From: Colin Giddings
Sent: 25 July 2018 14:03
To: Anita Gardner
Subject: LU/191/18/DOC

I've had a quick look at the conditions discharge documents which relate to EH/Site Licensing and would comment as follows:

Condition 5 –CMP

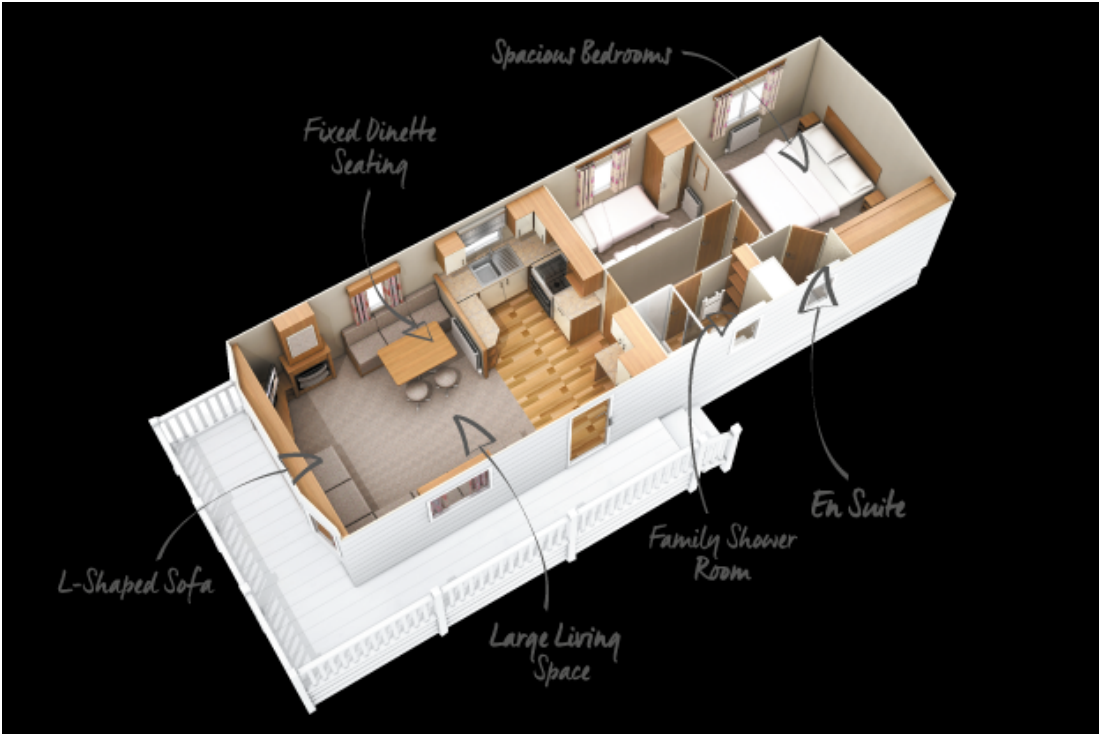
Condition 8 – Cycle Store

There is mention of a plan for the proposed wooden structure but I have not had sight of this. The site will need to comply with spacing and safety standards when in operation. Without details of the proposed structure I cannot comment further.
